Application No: FG/90/21/HH
Site Address: 1 Sea Drive Ferring BN12 5HD
Description of works: Erection of addition of second floor, part single, part two storey extension and wrap around terrace

Thank you for your internet representation made on 17th June 2021 which has been recorded as an objection with the comments as follows:

Project: Extension & Refurbishment	
for Chris Levett	
at 1 Sea Drive Ferring Worthing BN12 5HD	
Contact: Michael Austin R/BA E-mail: project@austinglebbon.co.uk Web: www.austinglebbon.co.uk Phone: 07958427610	
Dwg Ref: 2048 [PL] 06	Rev: - Date: May 2021

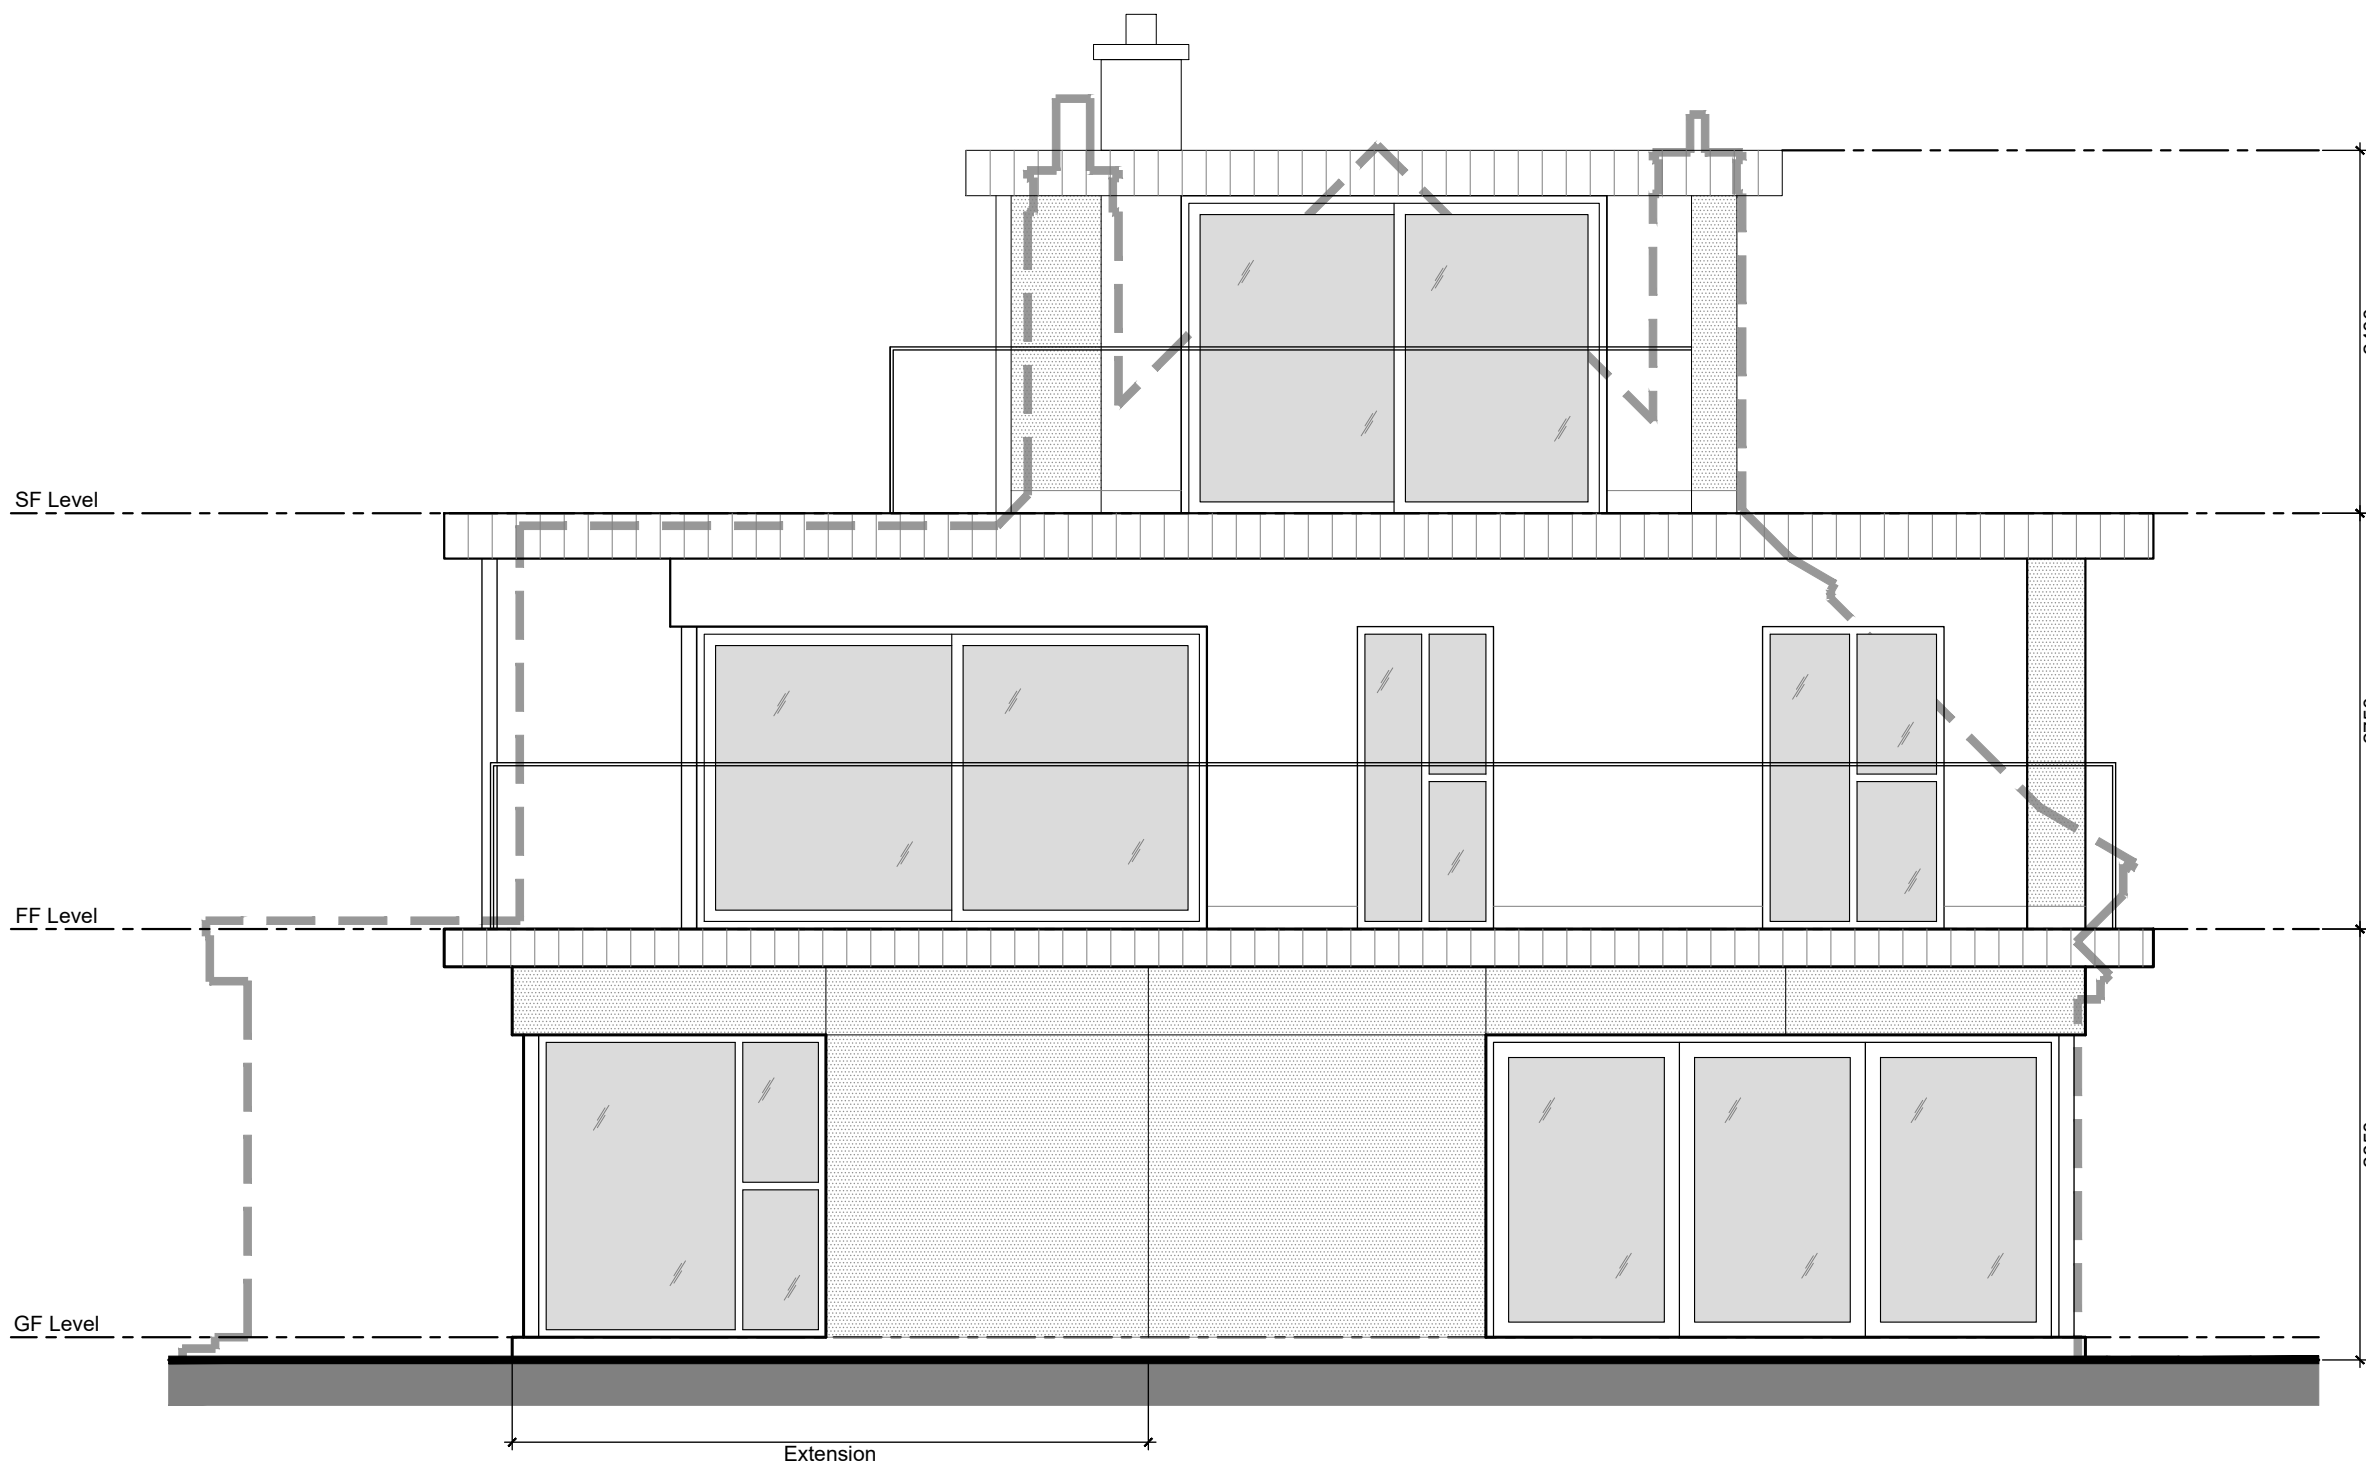
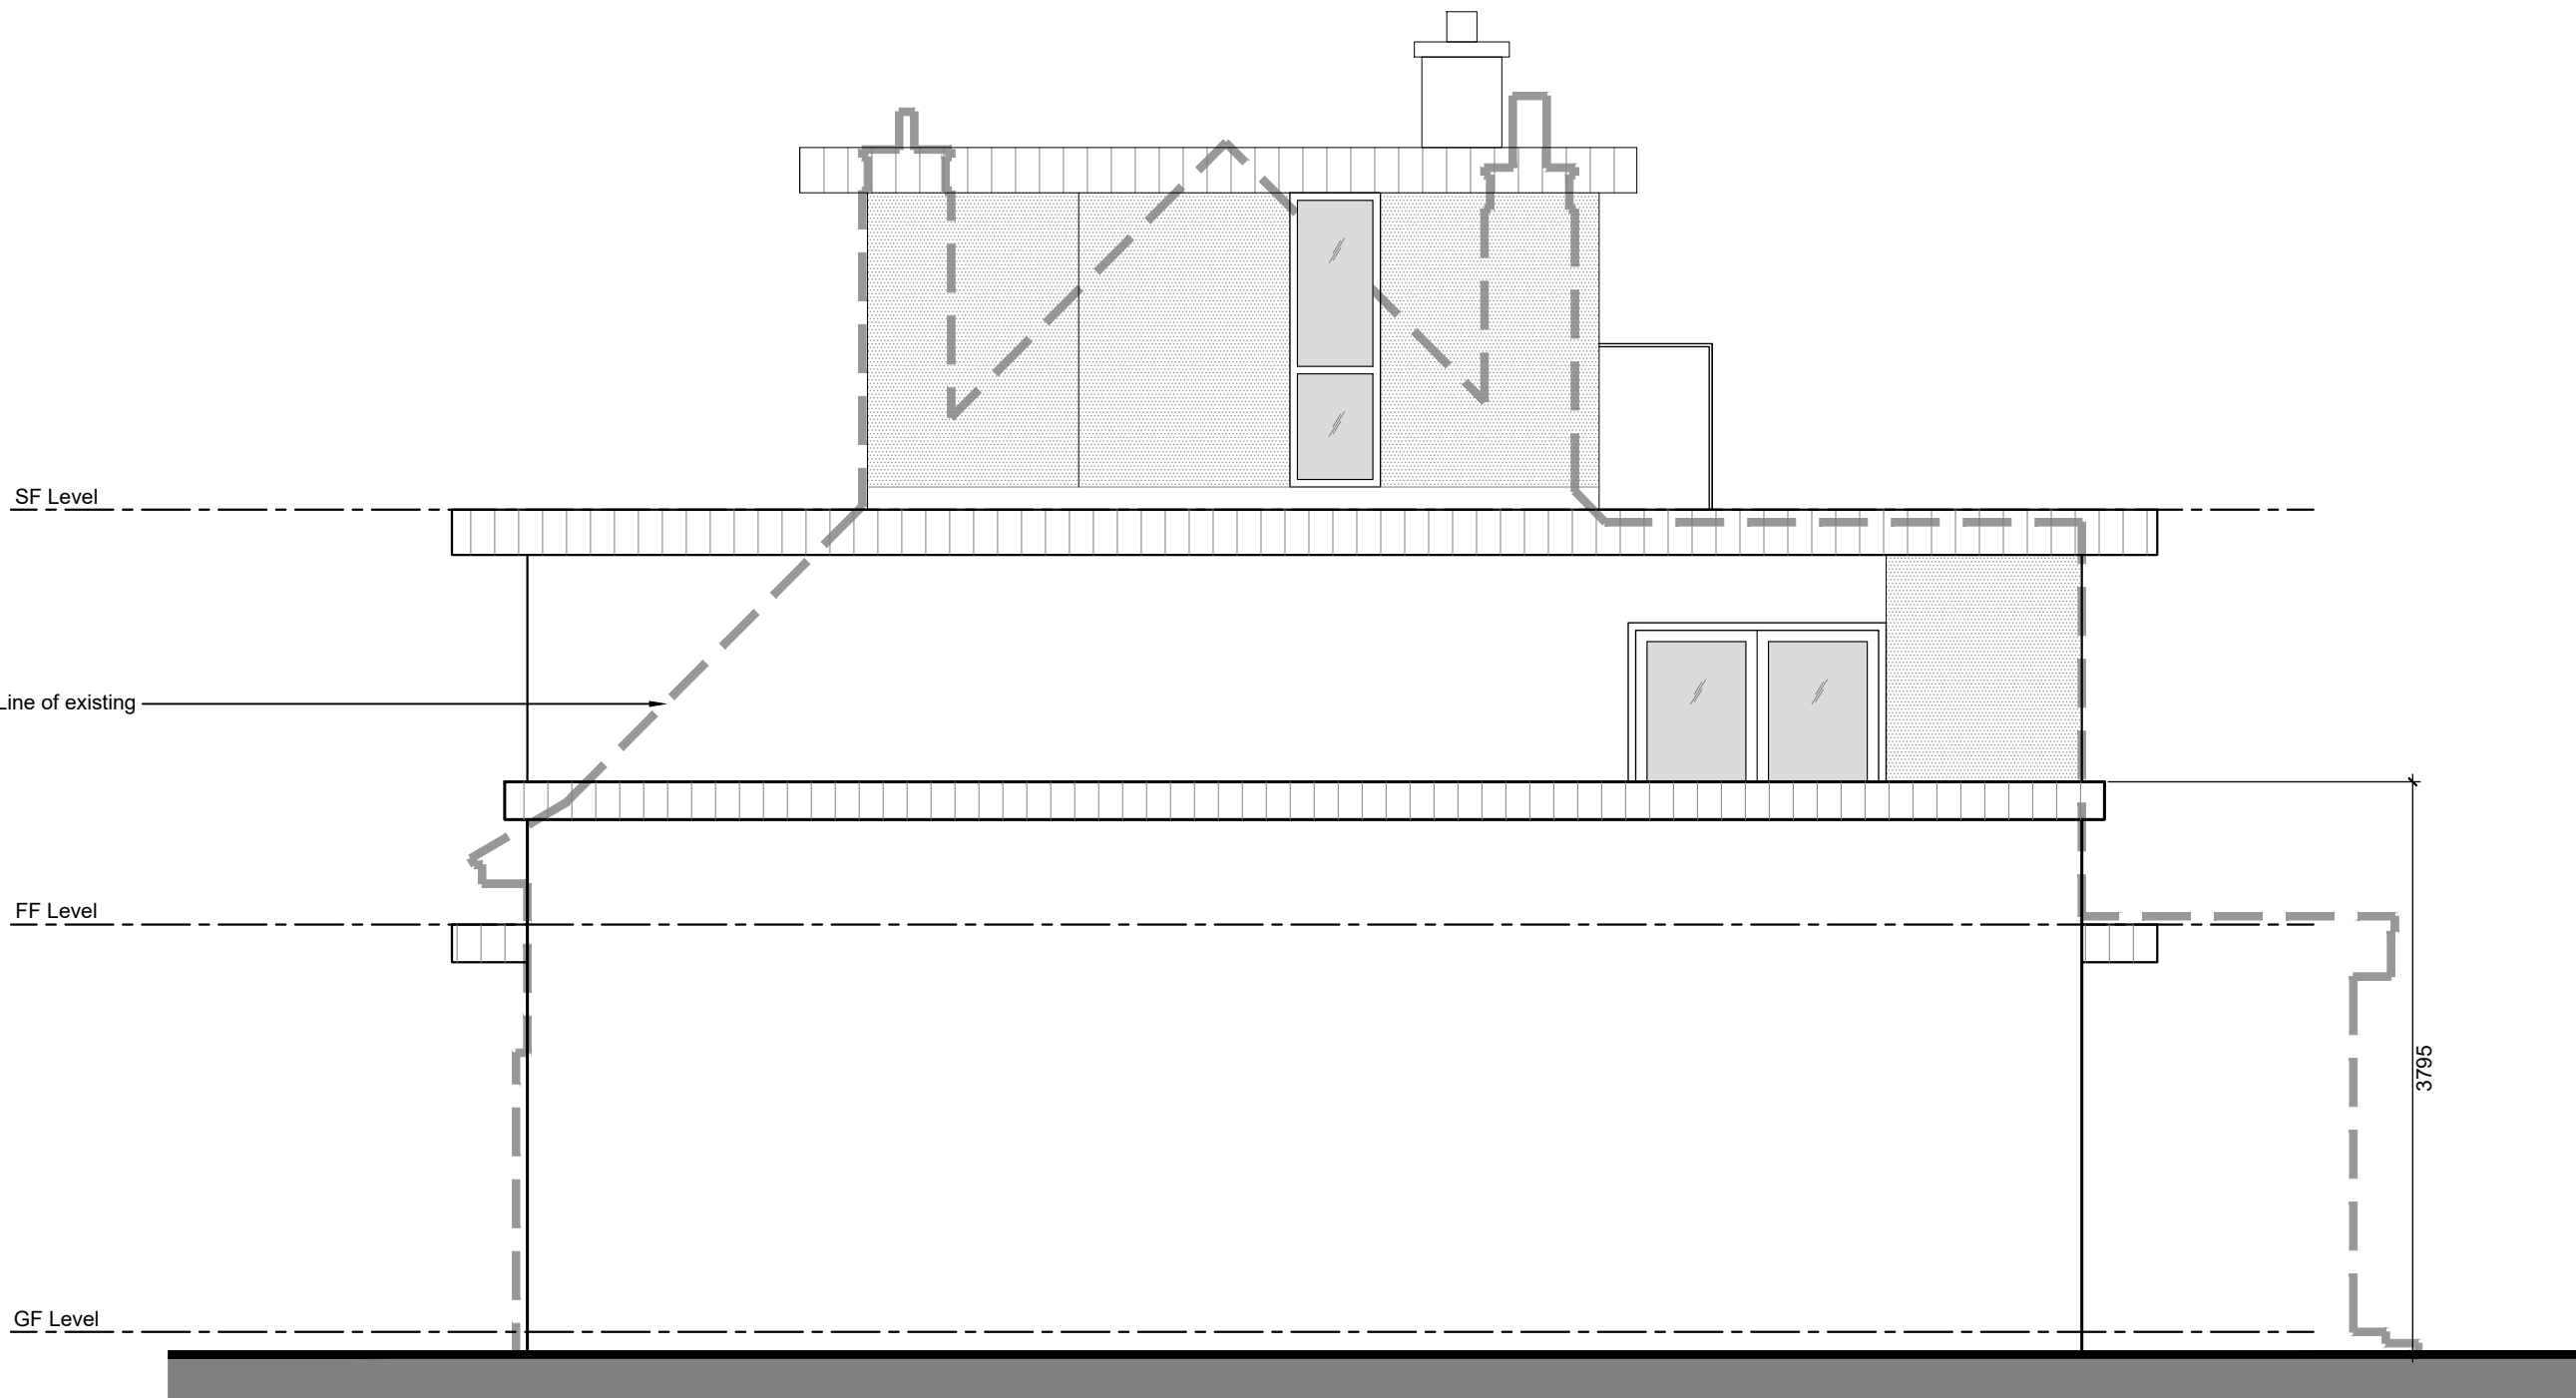
Neighbouring properties to the west and north and south will be adversely affected by the size and scale of the development.

The proposals have no regard for the intrusive impacts of the windows and balconies / terraces on the neighbouring properties. These would not only overlook the private garden spaces of the neighbouring dwellings (particularly no. 2 Sea Drive) but would give line of sight directly into the windows of those properties. The proposals would result in the loss of privacy and amenity value of previously relatively secluded gardens and balconies which are currently enjoyed by residents in the properties on three sides of the site.

Project: Extension & Refurbishment	
for Chris Levett	
at 1 Sea Drive Ferring Worthing BN12 5HD	
Contact: Michael Austin R/BA	
E-mail: project@austinlebbon.co.uk	
Web: www.austinlebbon.co.uk	
Phone: 07958427610	
Dwg Ref: 2048 [PL] 05	Rev: - Date: May 2021

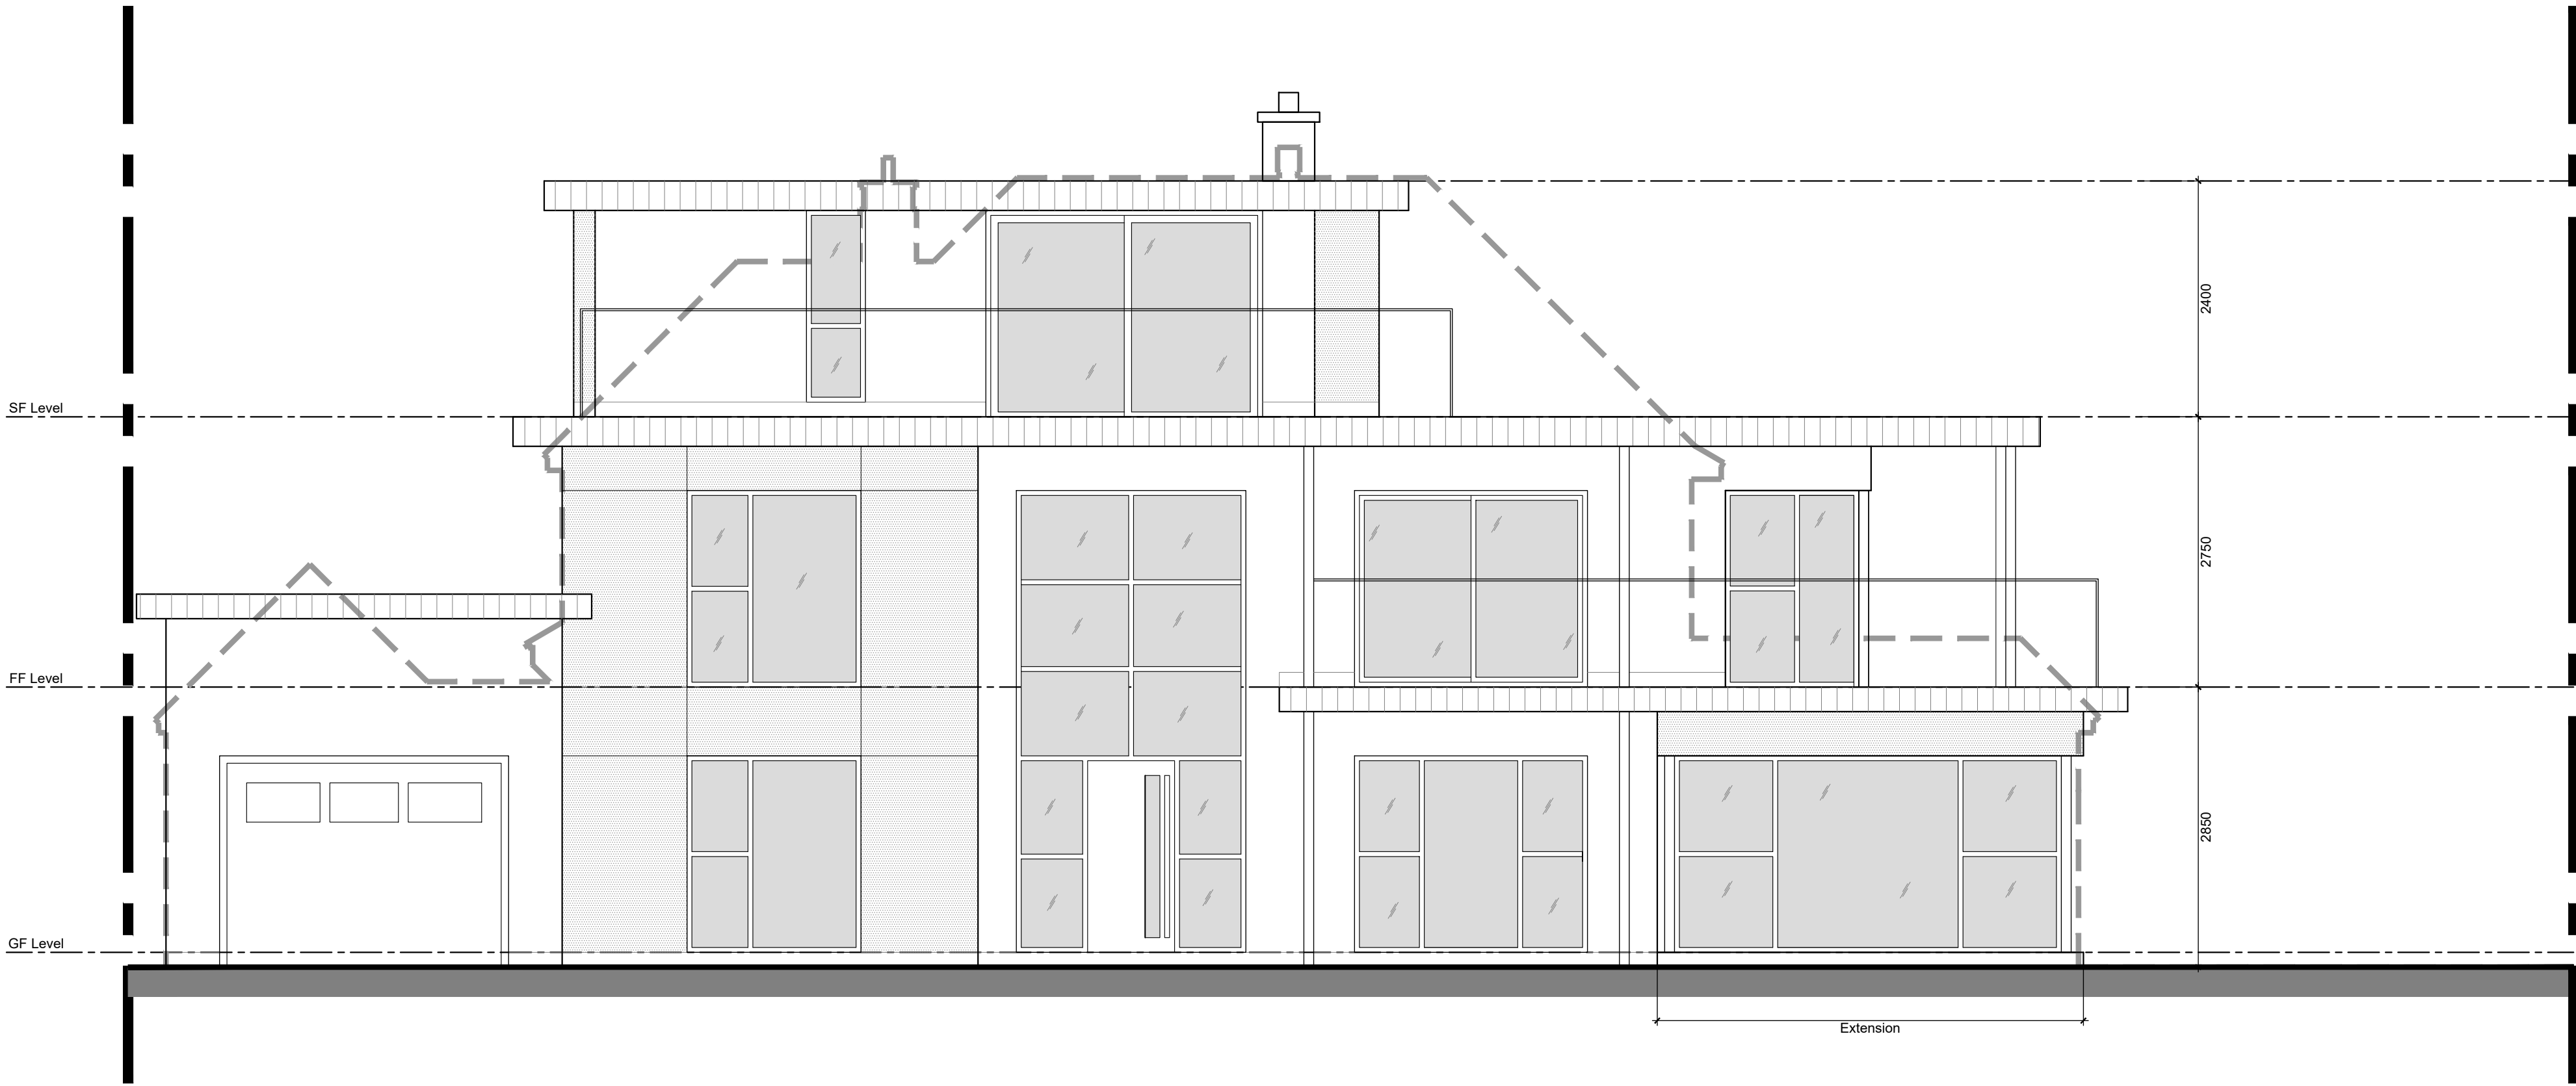
The design characteristics of the proposed third floor extension are out of keeping with the properties in Sea Lane and would be detrimental to the street scene and conflict with the scale and character of other residences visible on this approach to the village.
